DOC20/282305-4

Request for Advice - Moorebank Intermodal Precinct West - Stage 3 (SSD-10431)

Attachment A - EPA's comments and recommendations

EROSION & SEDIMENT CONTROL PLAN - MPWS3
1:1500 SCALE

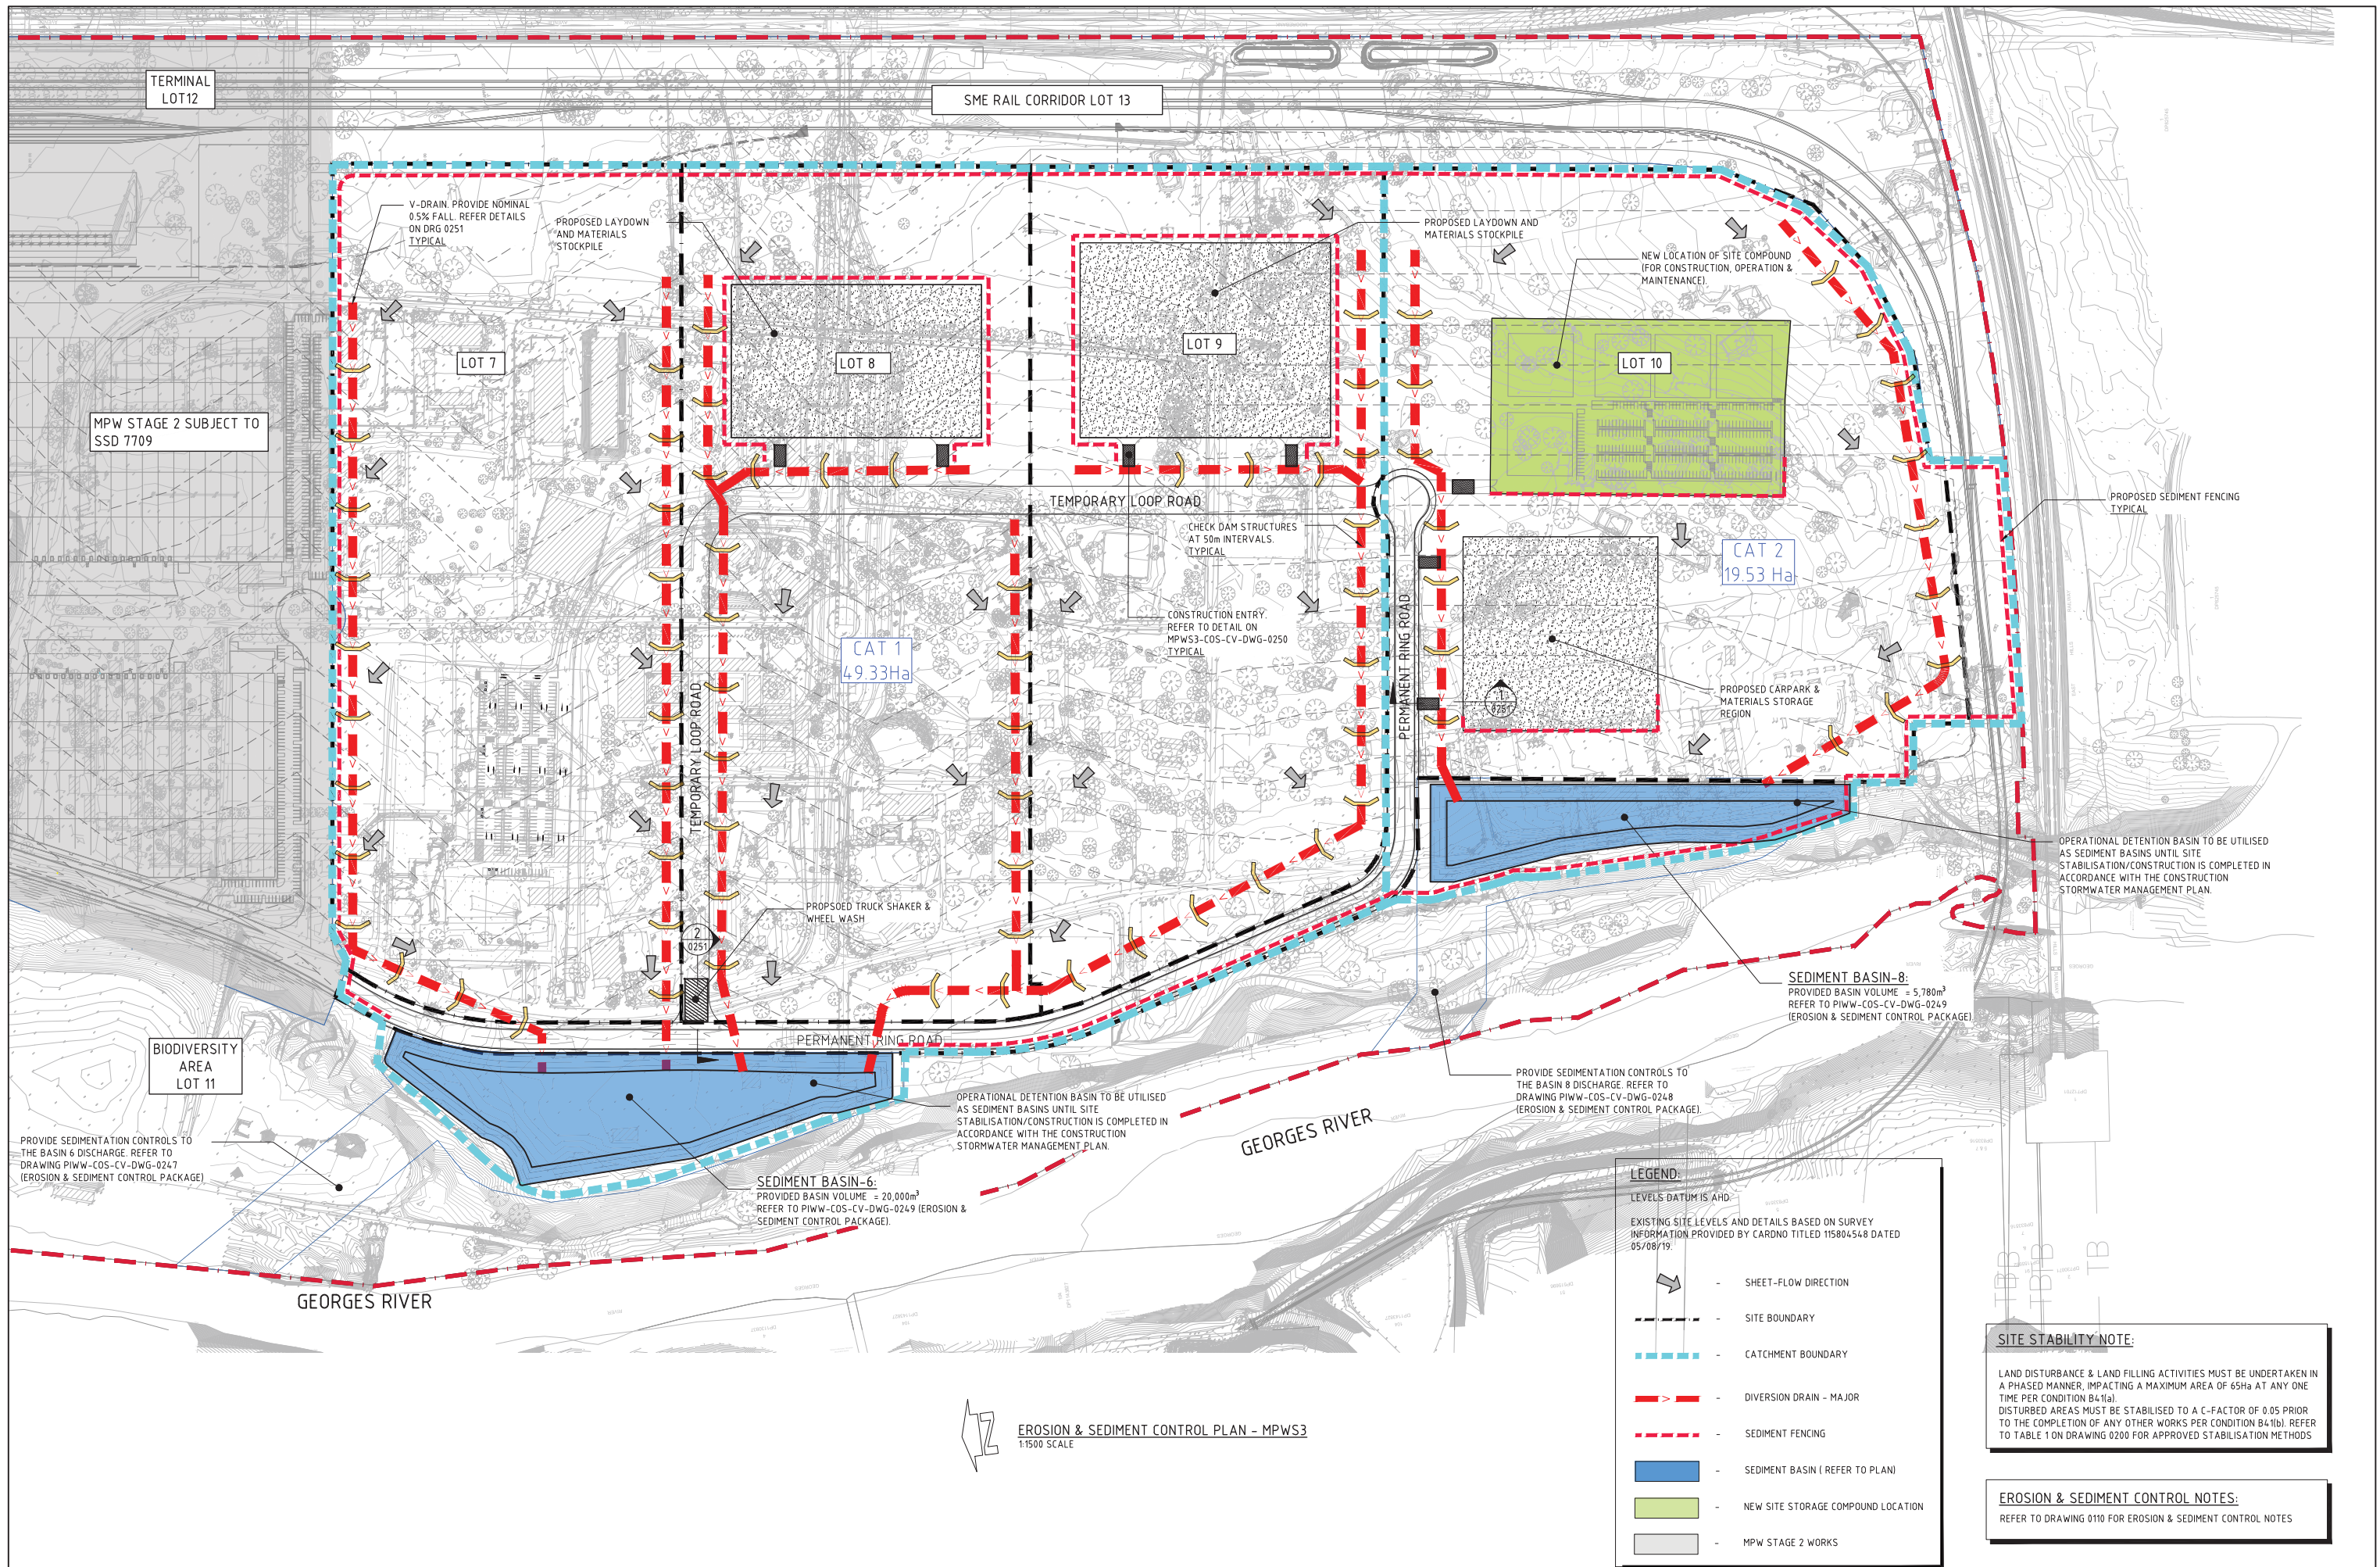
- An Erosion and Sediment Control Plan for construction works should be prepared in accordance with the *Blue Book Managing Urban Stormwater: Soils and Construction (2004)*, published by the NSW Government. The plan must show how dust, sediment and erosion will be controlled to prevent air pollution and water pollution.
